Subject: Rezoning Petition Review

Date of Review: December 22, 2022

Rezoning Petition #: 22-119

Proposed Zoning: UR-3 (CD)

REZONING PETITION
FOR PUBLIC HEARING

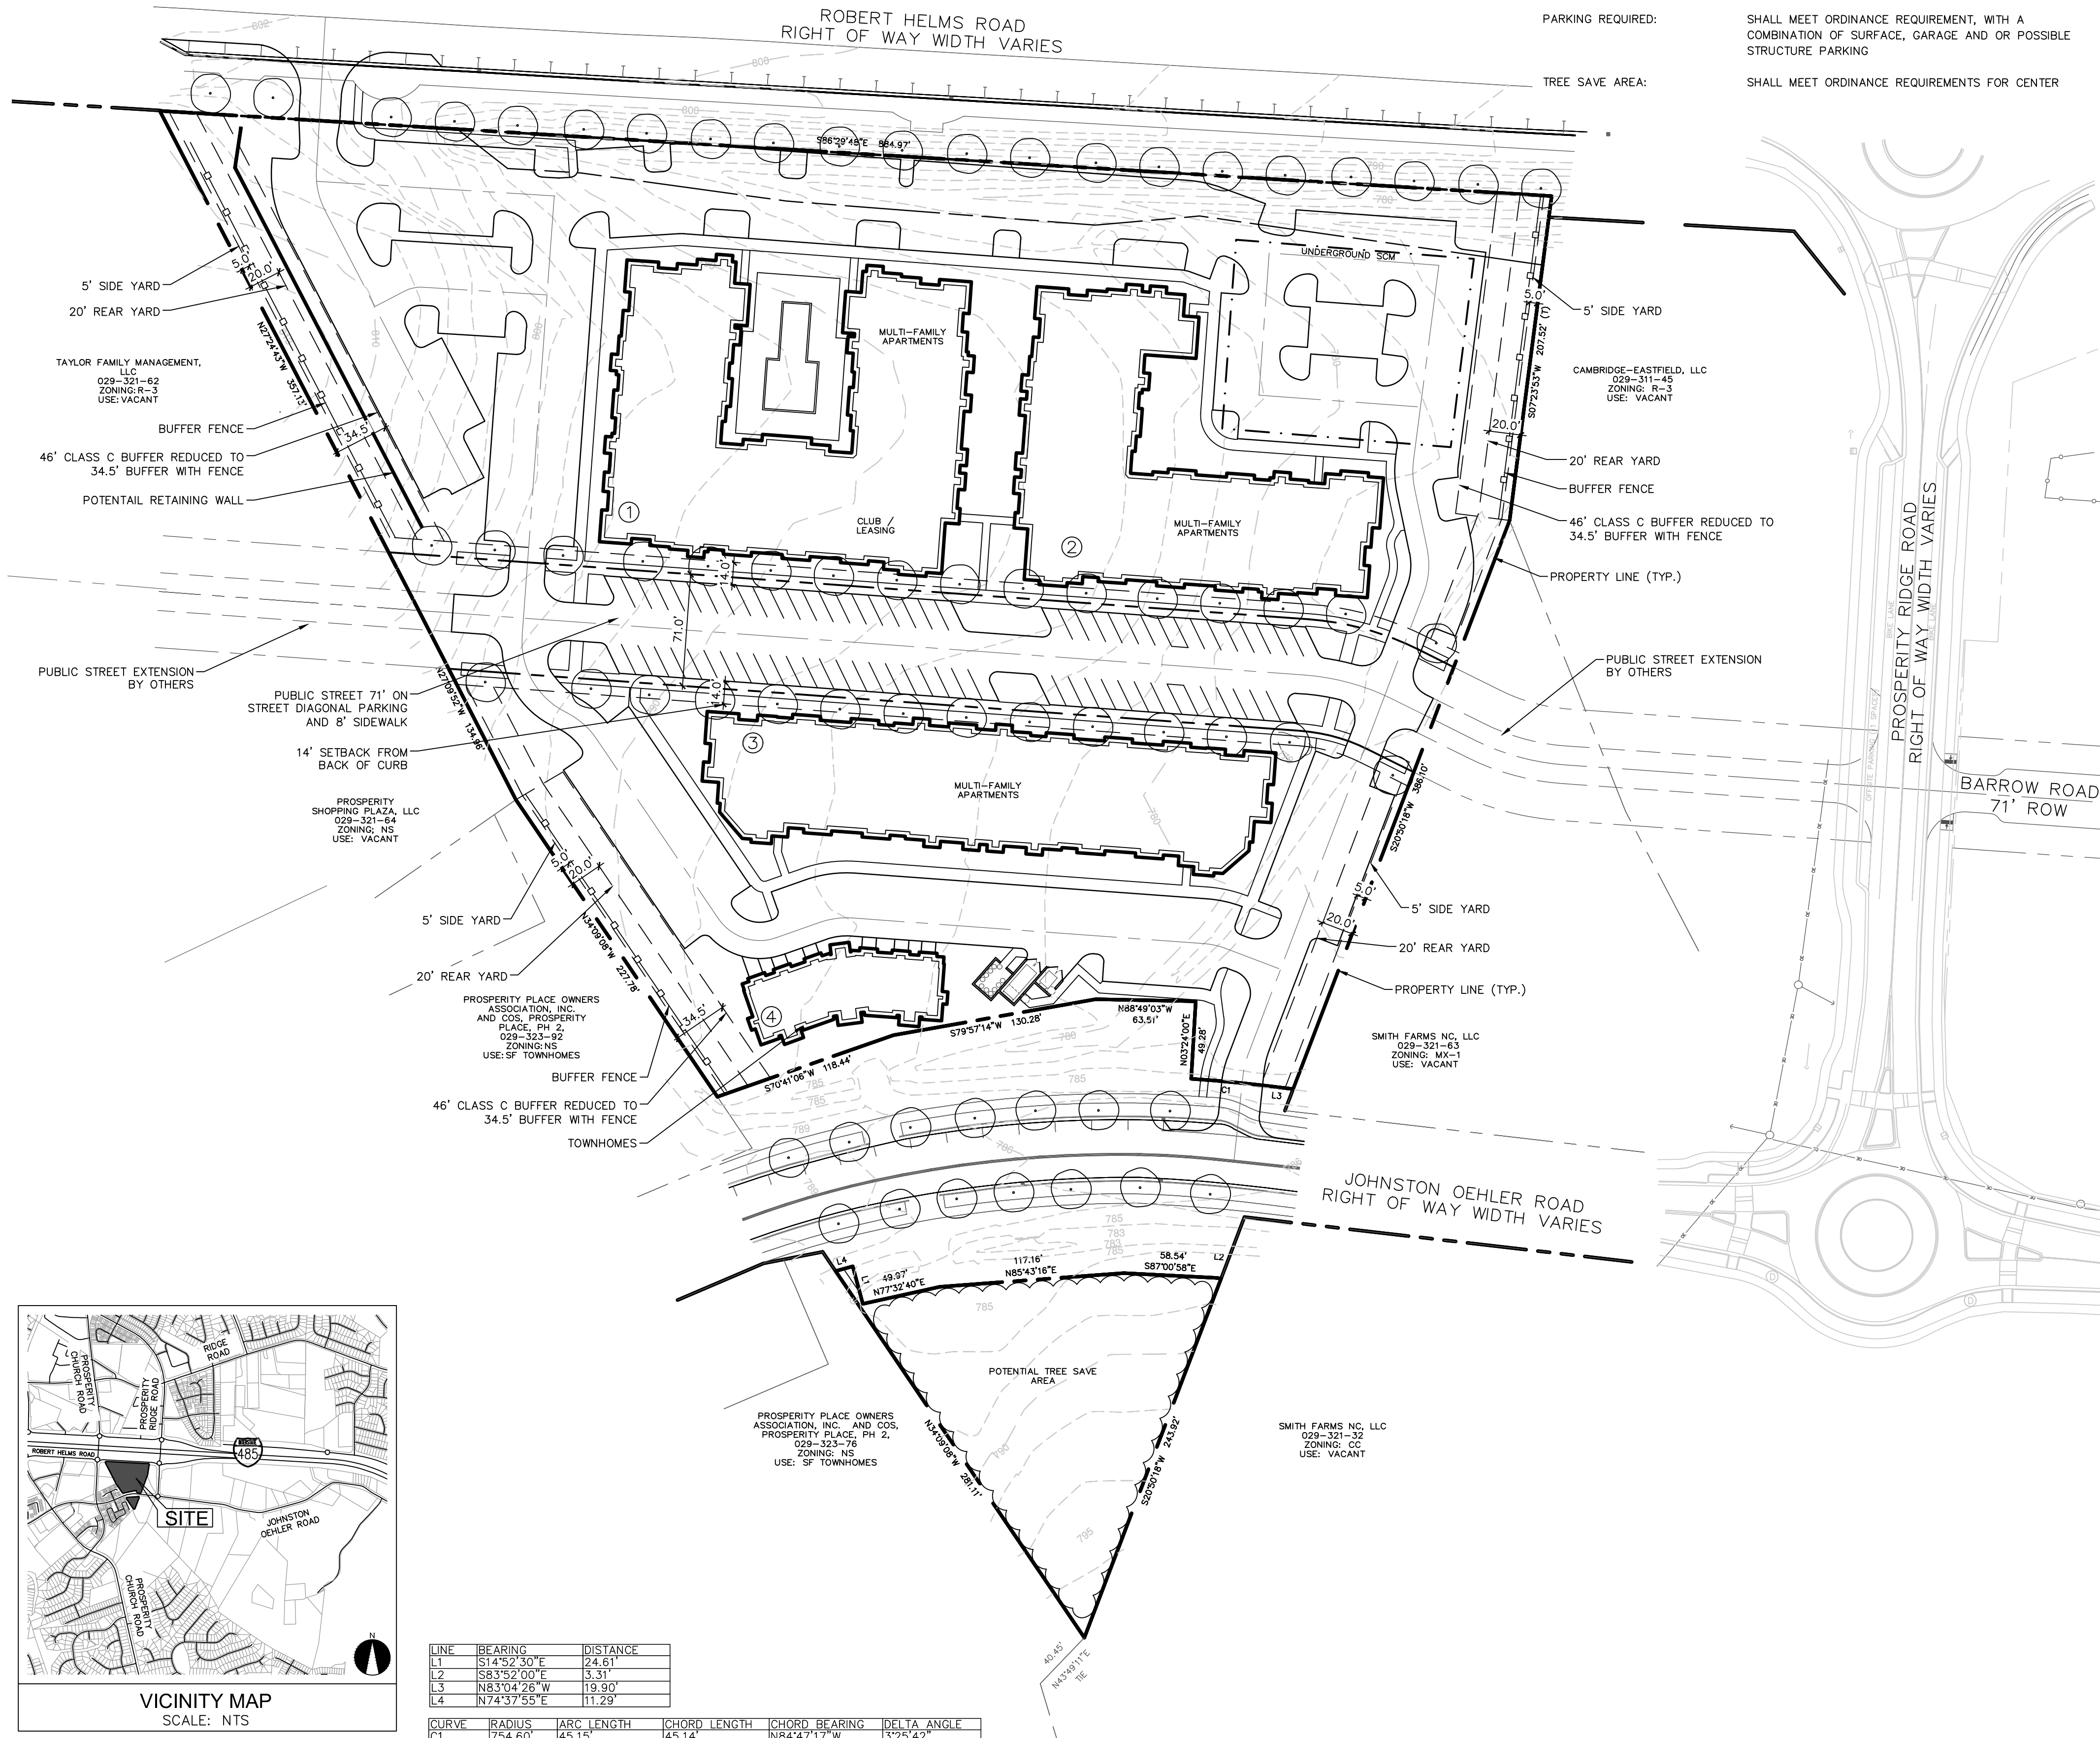
The proposed rezoning plan sheet indicates a proposed location for storm water management. Please include the following notes on the plan sheet under "Environmental Features": *The location, size, and type of storm water management systems depicted on the Rezoning Plan are subject to review and approval as part of the full development plan submittal and are not implicitly approved with this rezoning. Adjustments may be necessary in order to accommodate actual storm water treatment requirements and natural site discharge points.*

City of Charlotte GIS data indicates a 50-ft Undisturbed PCSO buffer across the site. Please show and label *Potential 50-ft Undisturbed PCSO Buffer* on the site plan. Any increase of impervious area within such buffers may not be allowed and is not approved with the rezoning process. Stream Delineation Reports are subject to review and approval by Charlotte Storm Water Services. Please include the following note under Environmental Features: *"Development within any SWIM/PCSO Buffer shall be coordinated with and subject to approval by Charlotte-Mecklenburg Storm Water Services and mitigated if required by City ordinance. Petitioner acknowledges intermittent/perennial stream delineation reports are subject to review and approval upon submission of development plans for permitting and are not approved with rezoning decisions."*
